URBAN COLLECTION AT PALMER VILLAGE

FINAL GRADING PLANS

Engineering Review
12/30/2020 12:28:40 PM
dsdrice
JeffRice@elpasoco.com
(719) 520-7877
EPC Planning & Community
Development Department

URBAN COLLECTION AT PALMER VILLAGE	SWALE CROSS SECTIONS	GEC PLANS
SHEET 3 OF 10	JOB NO. 25149.01

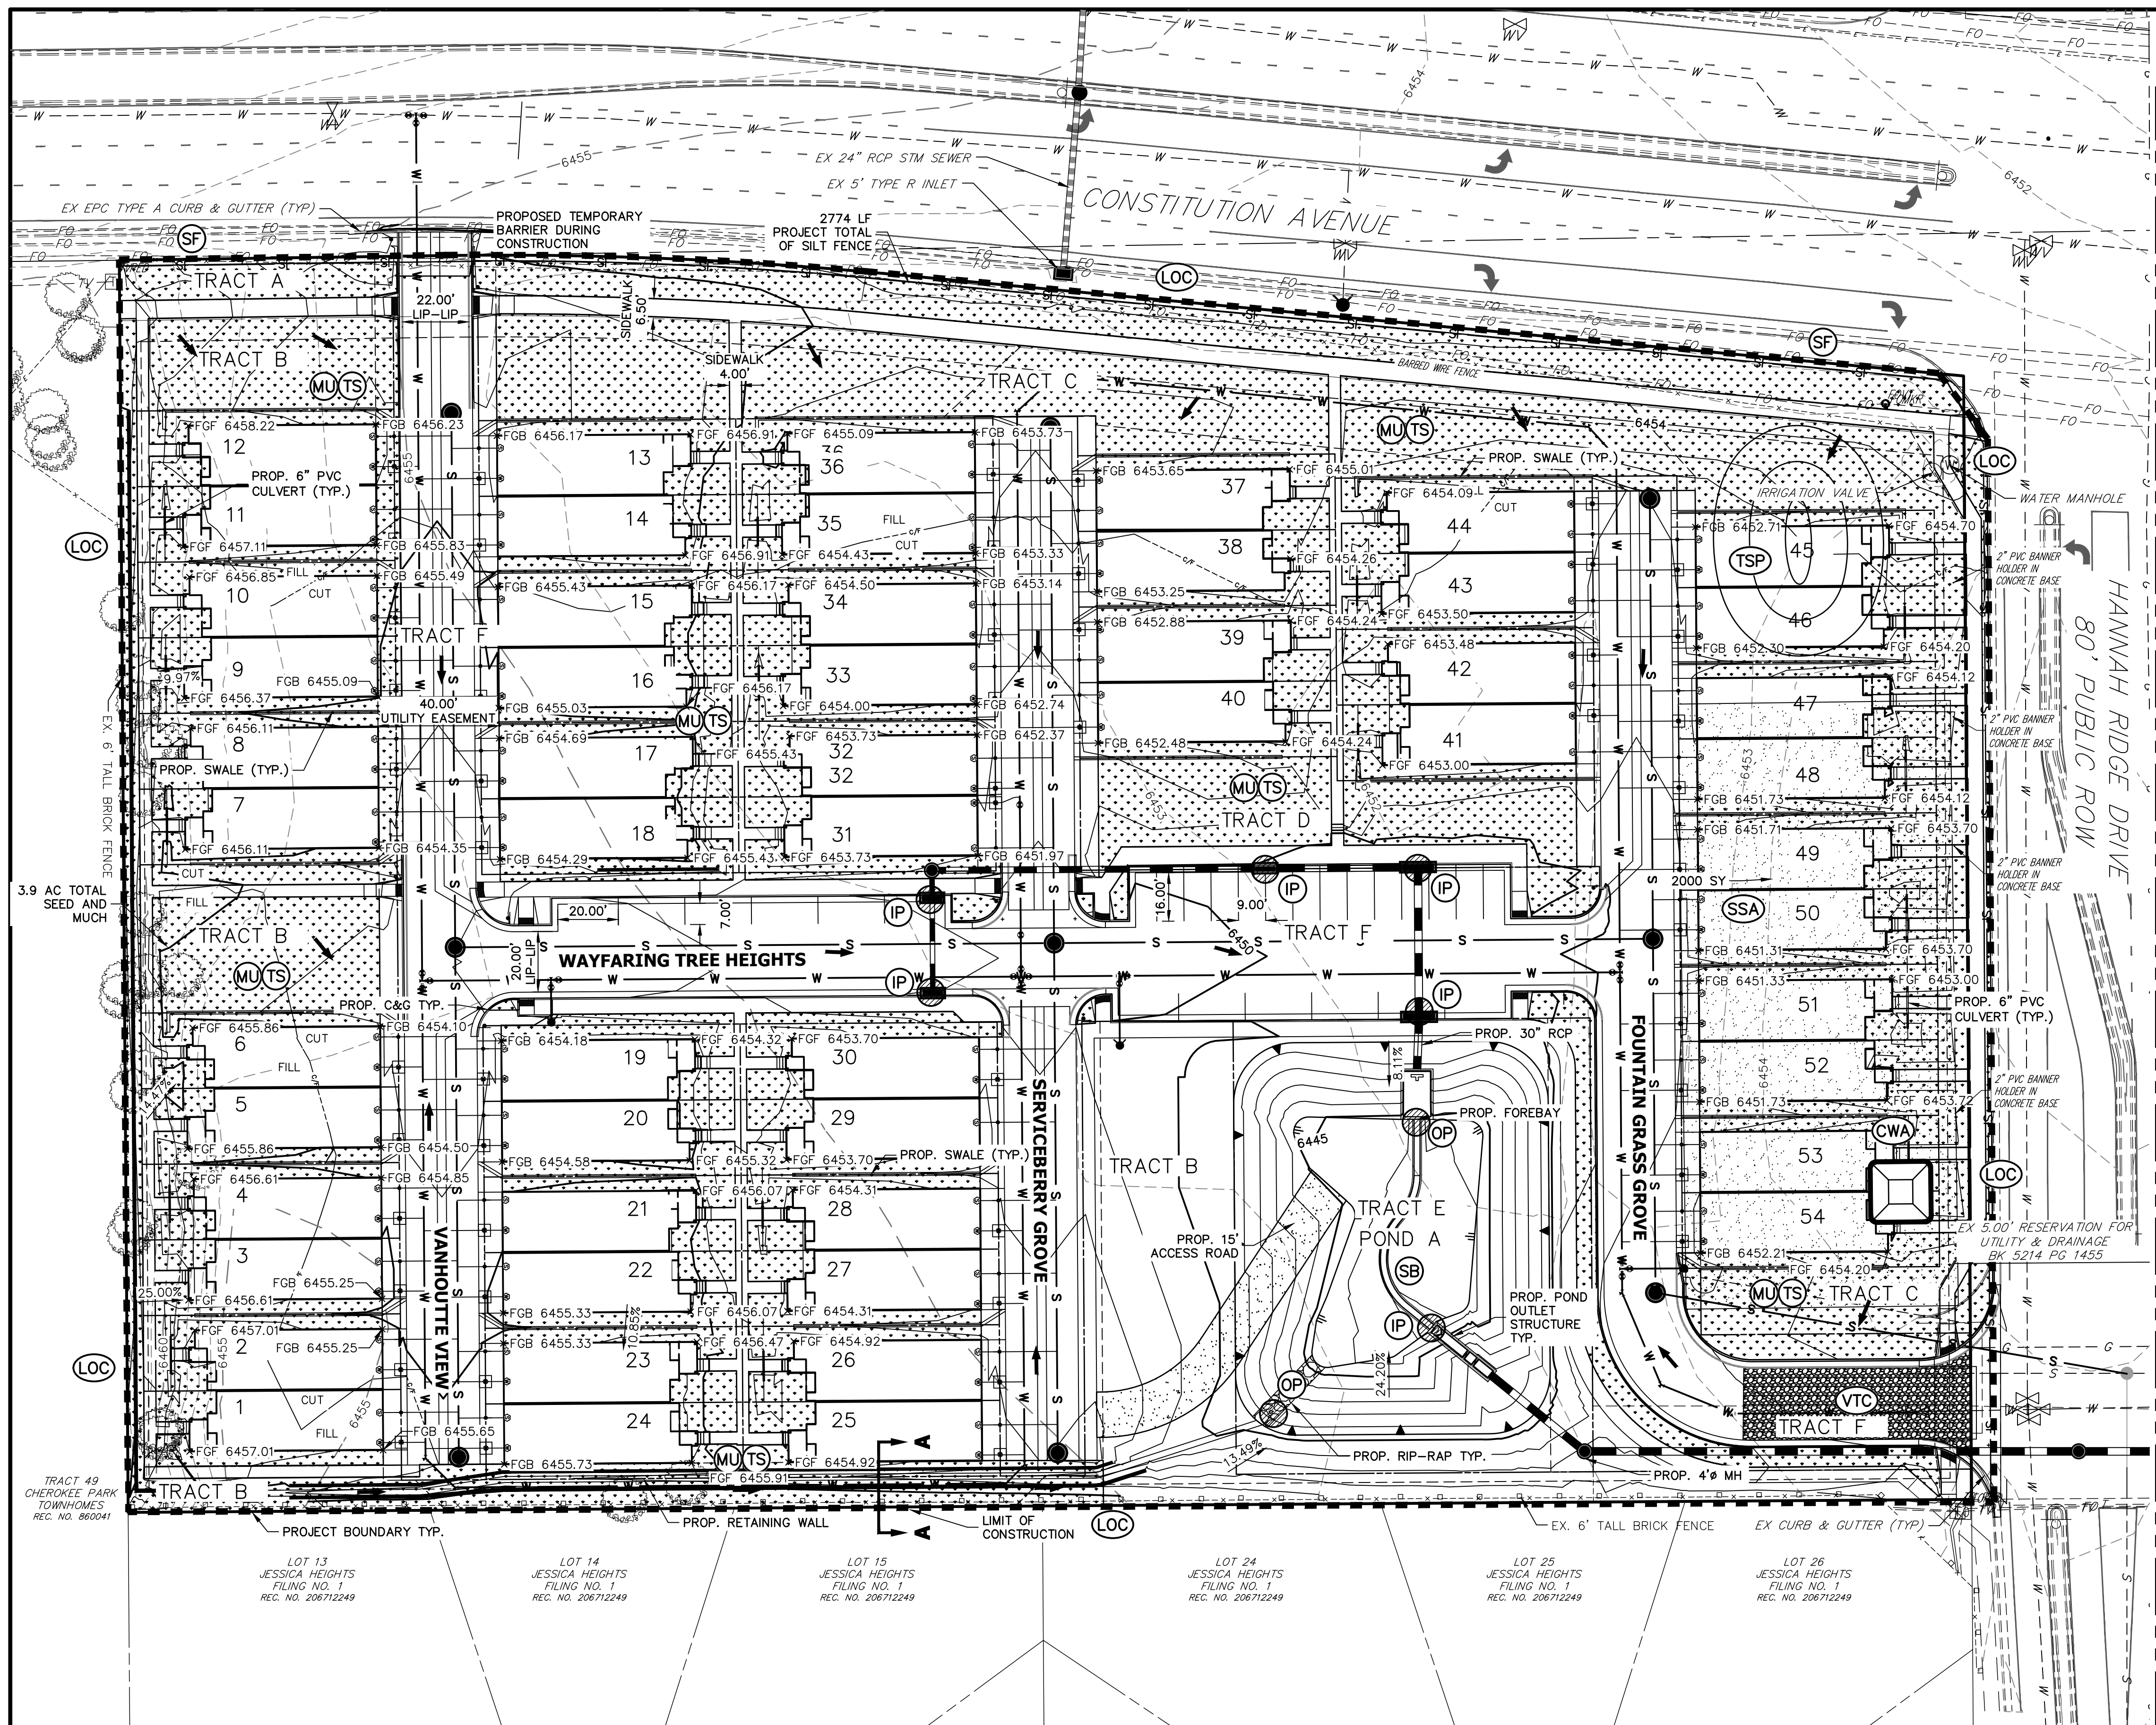
Provide cross-sections of swales.
